An  
Coimisiún  
Pleanála

**Direction**  
**ABP-320327-24**

The submissions on this file and the Inspector's report were considered at a meeting held on 19/11/2025.

at Kippure Lodge and Holiday Village, Kippure Estate, Manor Kilbride, Blessington, County Wicklow is or is not development or is or is not exempted development:

6 02.00 First Floor
1 : 100

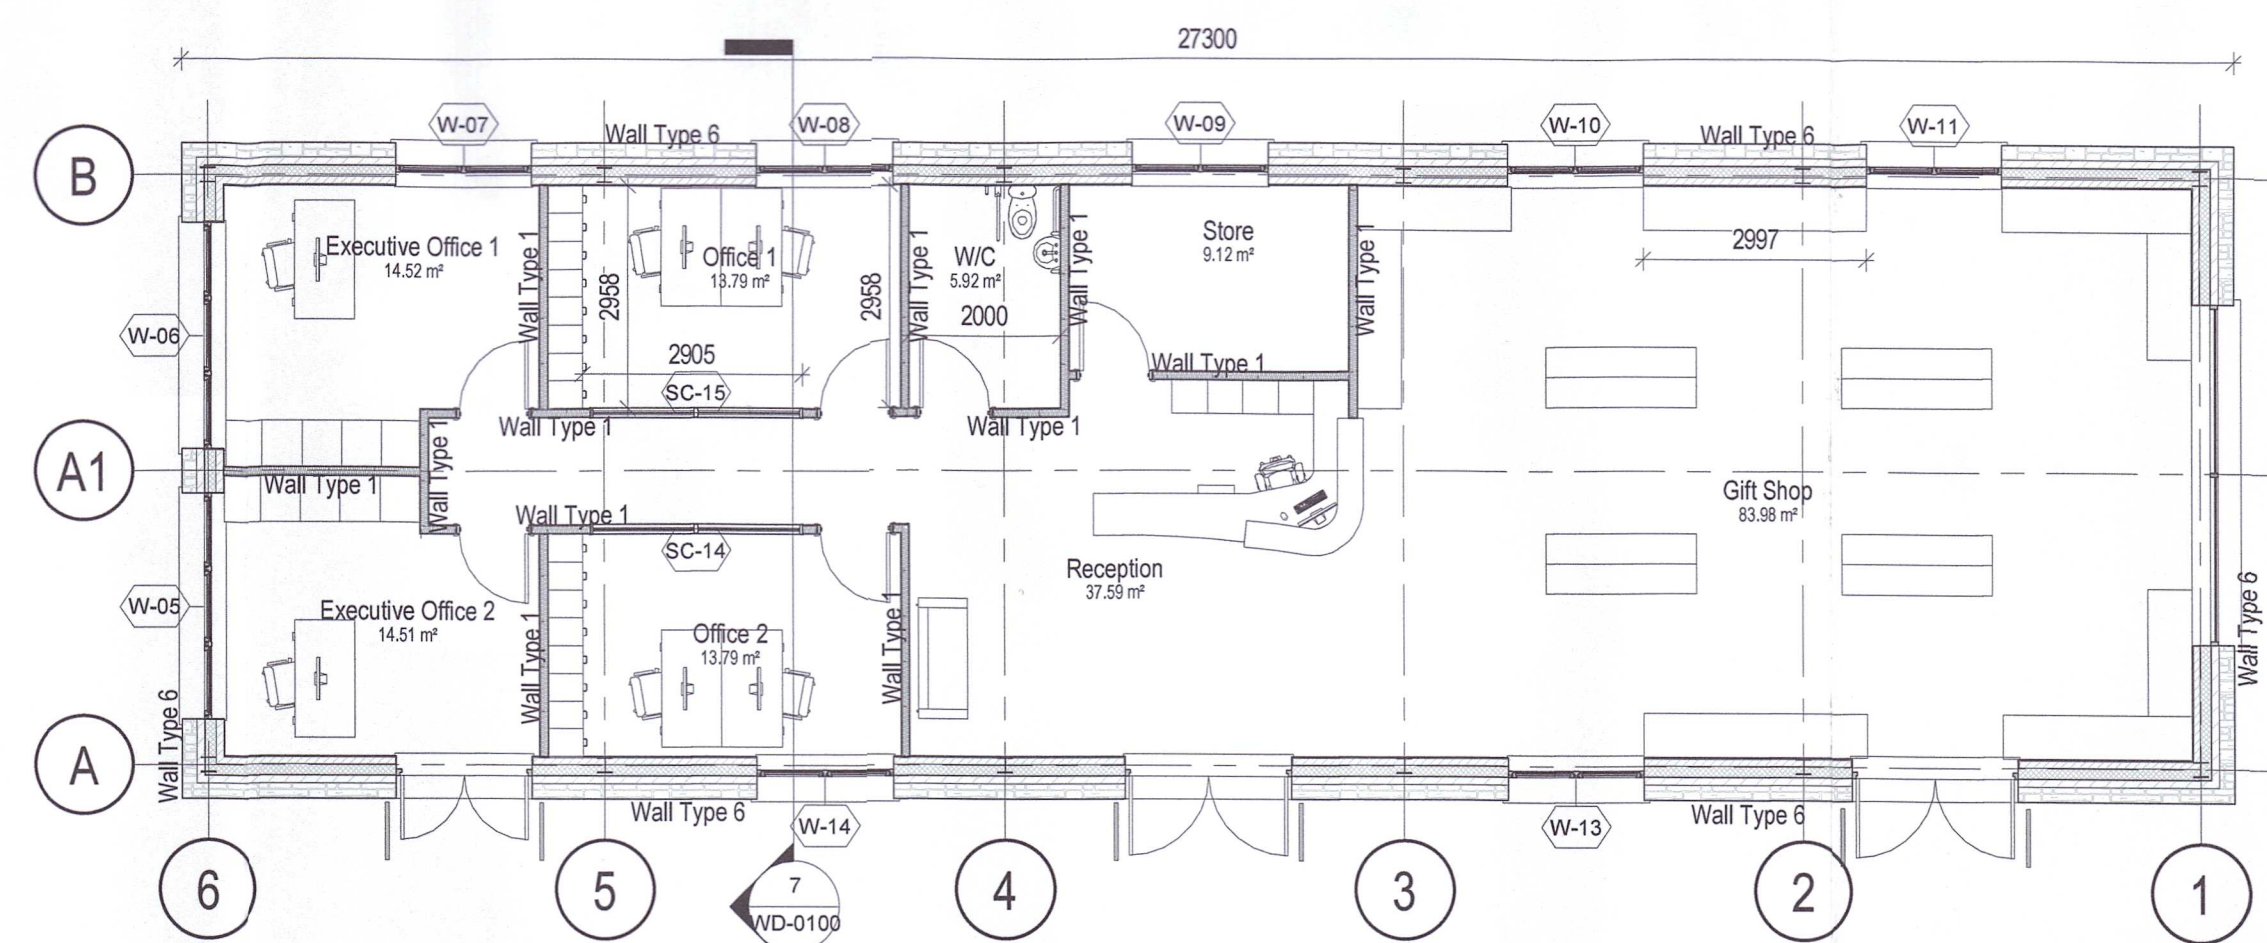
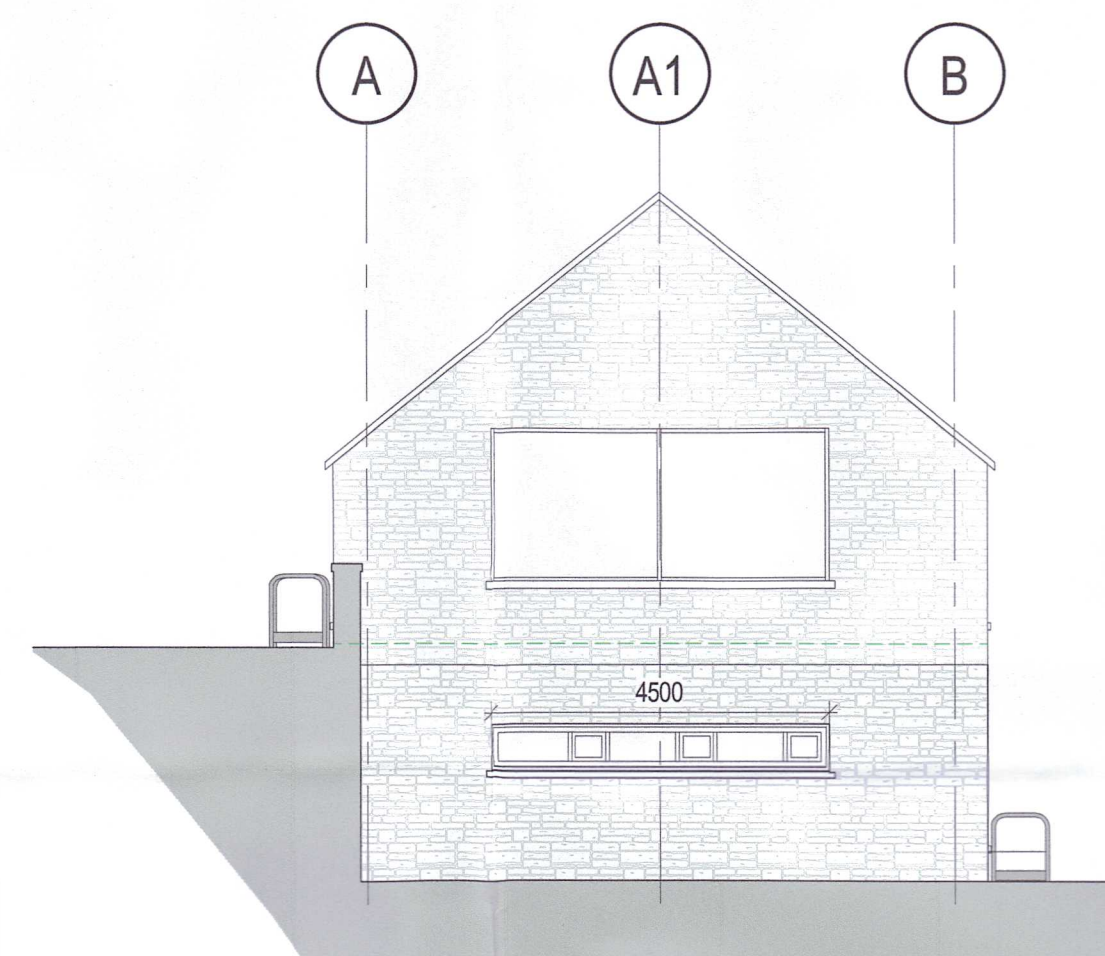
- (h) Structure Number 10: Having regard to the significant nature and scale of the works to the original structure 'Belfry' and the development approved under planning authority Register Reference 05/2792 the works do come within the scope of Section 4(1)(h) of the Planning and Development Act, 2000, as the works materially affects the external appearance of the structure so as to render its appearance inconsistent with the character of the structure. Therefore, the works do not constitute exempted development.

Structure 12 - Plans,
Elevations & Section

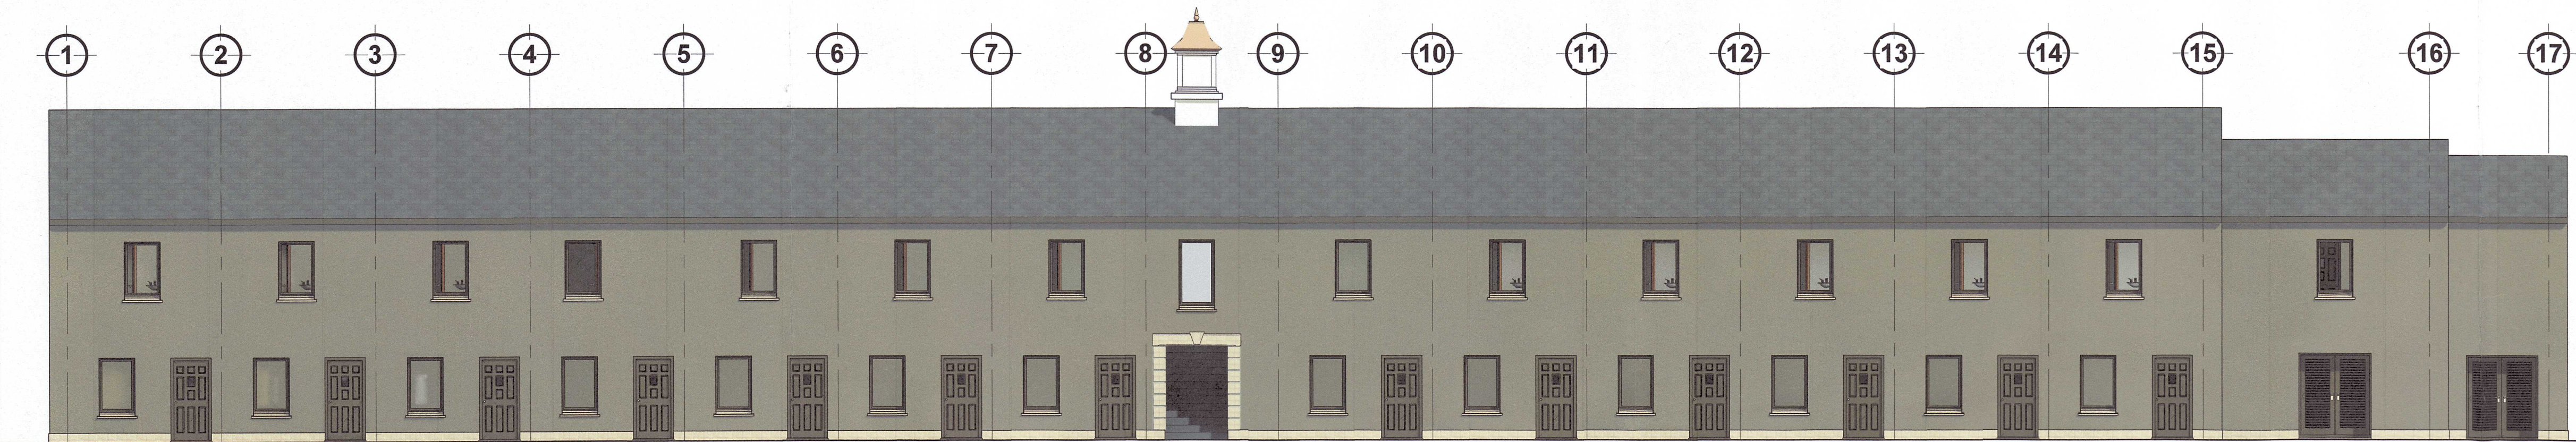
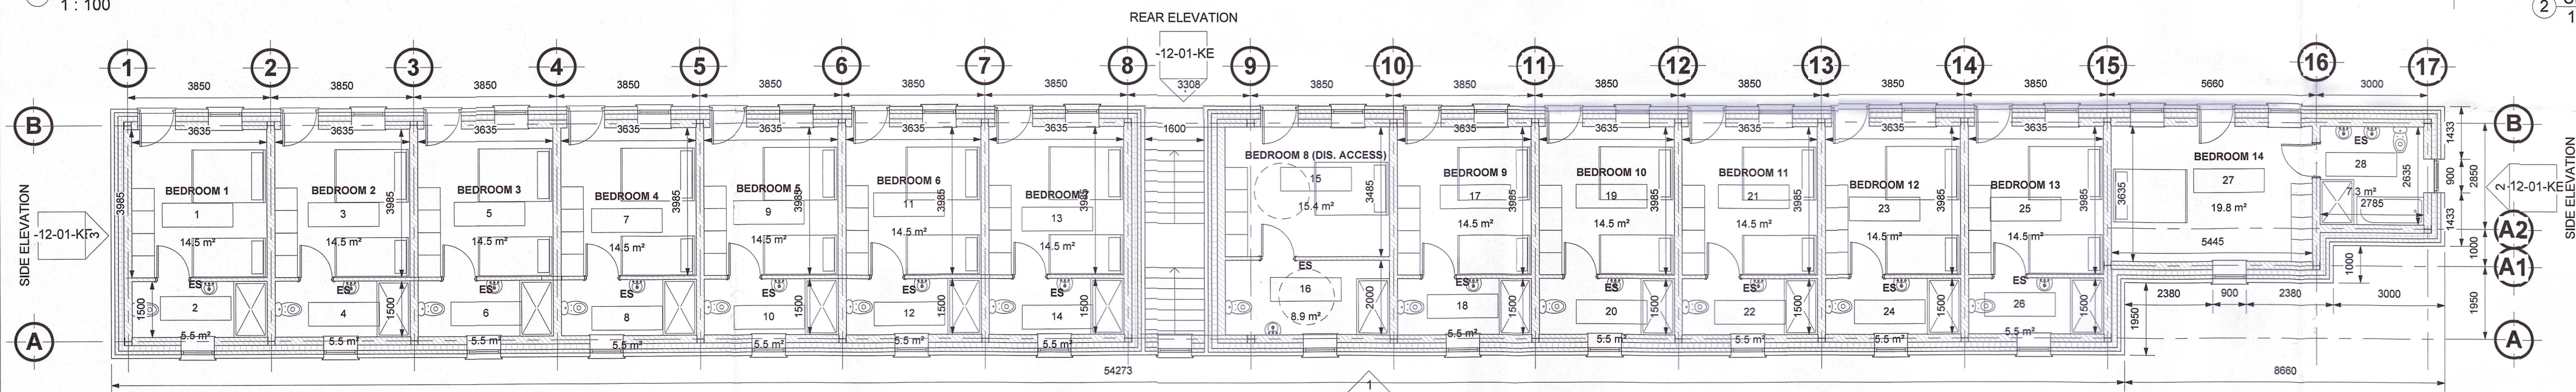
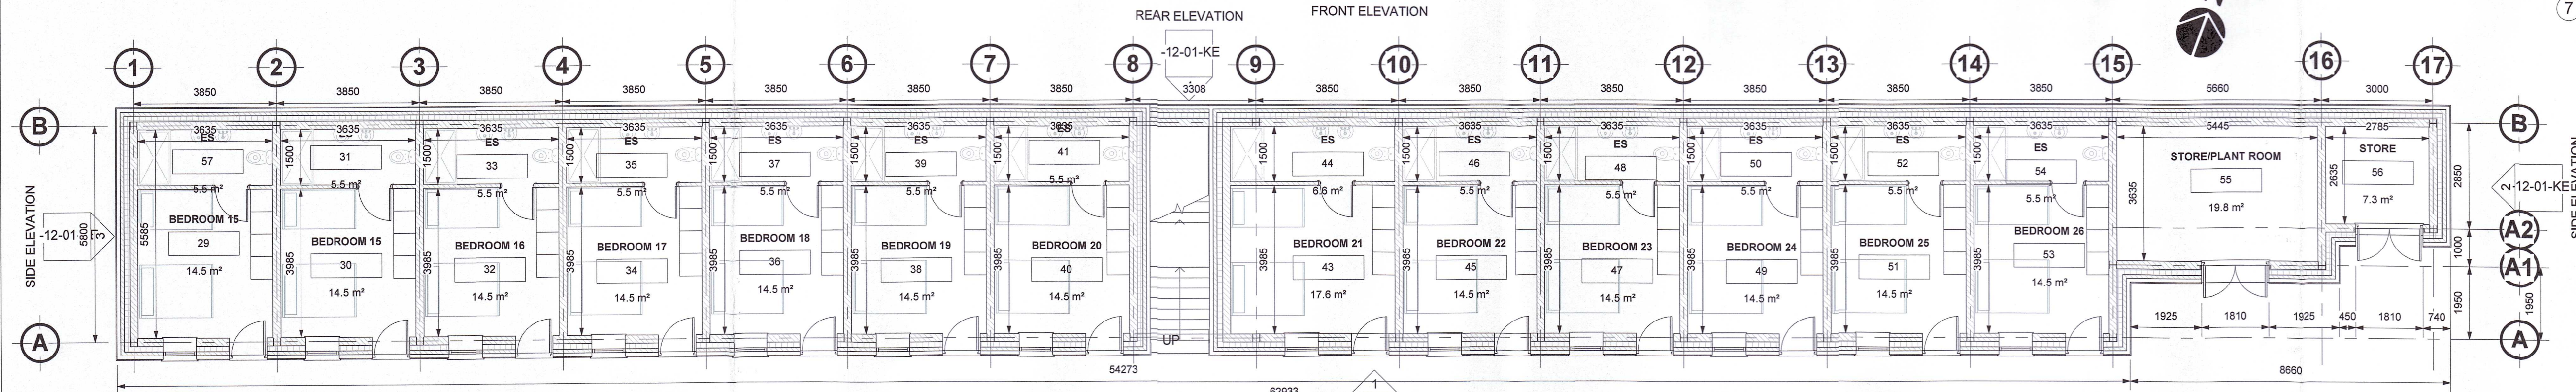
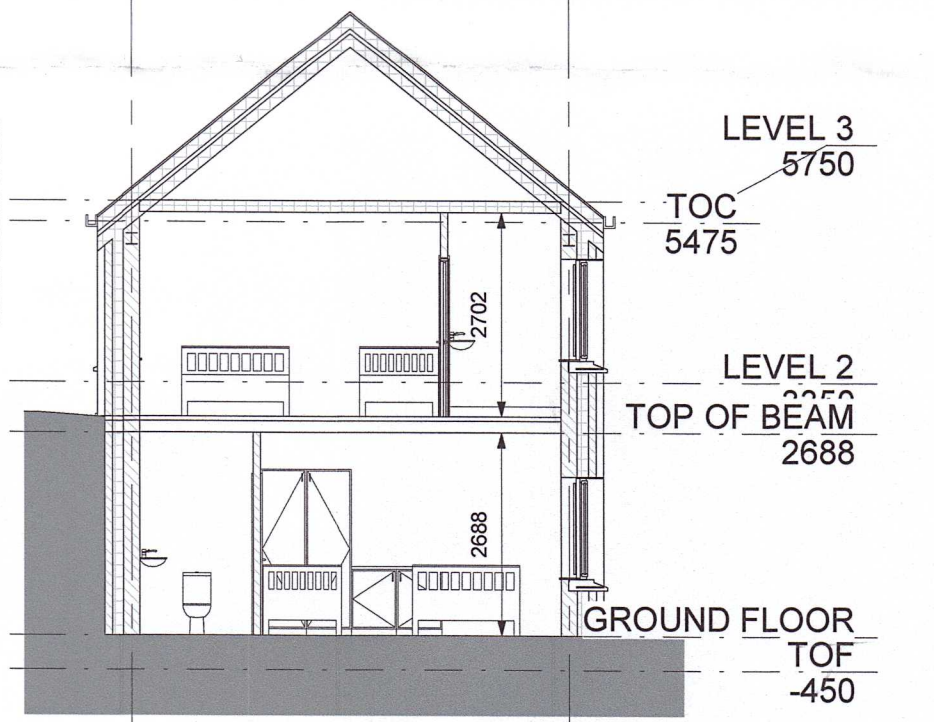
- (j) Structure Number 12: Accommodation block does not come within the scope of Section 4(1)(h) of the Planning and Development Act, 2000, as it is a new structure. The construction of Structure Number 12 does not fall within the scope of Class 14(h), (i) or (j), of Part 1 of Schedule 2 of the Planning and Development Regulations, 2001 (as amended), as the development does not comprise a change of use. The construction of Structure Number 12 does not fall within the scope of Class 20F of Part 1 of Schedule 2 of the Planning and Development Regulations, 2001 (as amended), as the development does not comprise a change of use. No evidence that Structure Number 12 was carried out in accordance with the provisions of the European Union. (Planning and Development) (Displaced Persons from Ukraine Temporary Protection) Regulations 2022 (S.I. Number 306/2022). No evidence that the structure is related to accommodation for displaced persons, given the definition of such persons set out in Annex 2 of the Council Implementing Decision (EU) 2022/382. Therefore, the works do not constitute exempted development.

JOB TITLE	Development at Kippure Estate	
CLIENT	Tondo Ltd.	DATE
LOCATION	Manor Kilbride, Blessington, Co. Wicklow.	14/02/24
SDSUS	APPROVED	SCALE
DRAWN	APPROVED	1:100 @ A3
BORNING No.	Structure No. 1	REVISION
PL1081KE	Gate Lodge A.

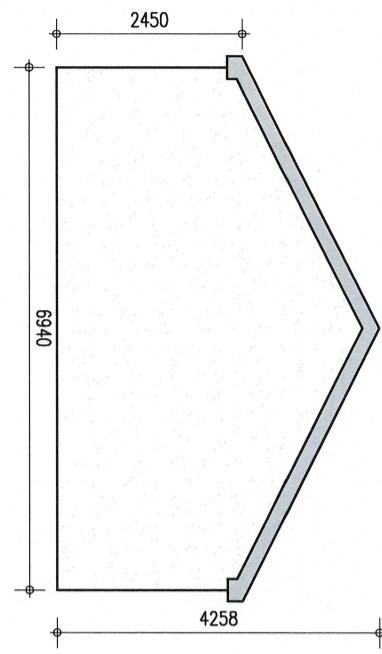
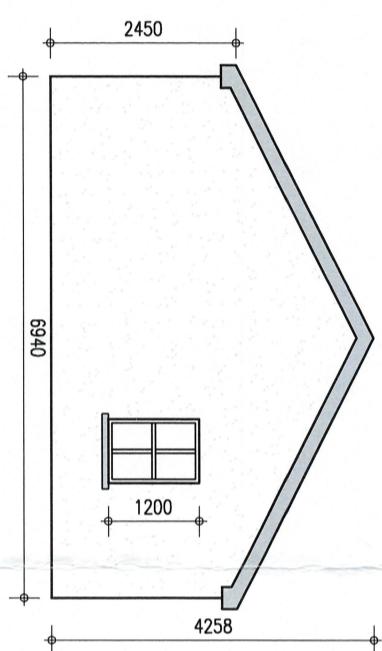
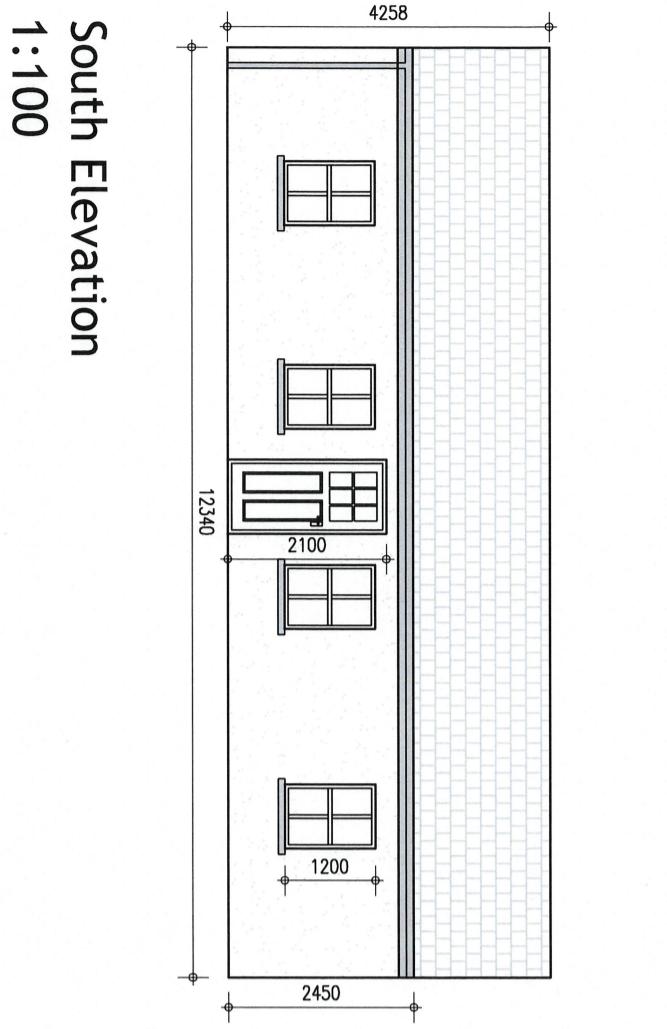
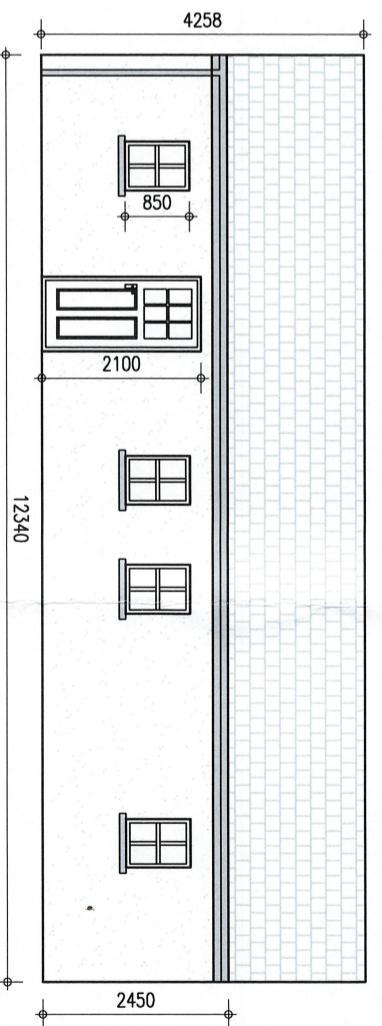
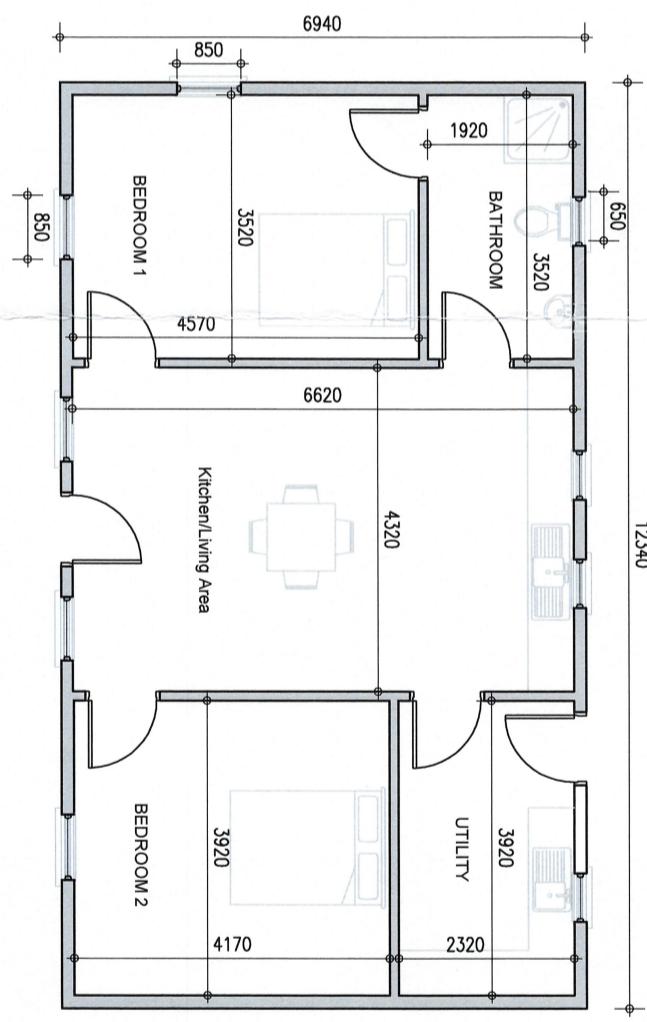
- (a) Structure Number 1: Gate Lodge A and Gate Lodge B do not come within the scope of Section 4(1)(h) of the Planning and Development Act, 2000 (as amended) as they are new structures. These structures do not fall within the scope of Class 17 of Part 1 of Schedule 2 of the Planning and Development Regulations, 2001 (as amended) as they are to provide accommodation for security staff for persons occupying the facility during its operational phase and do not relate to accommodation for persons employed or otherwise during construction works. Therefore, these structures do not constitute exempted development.
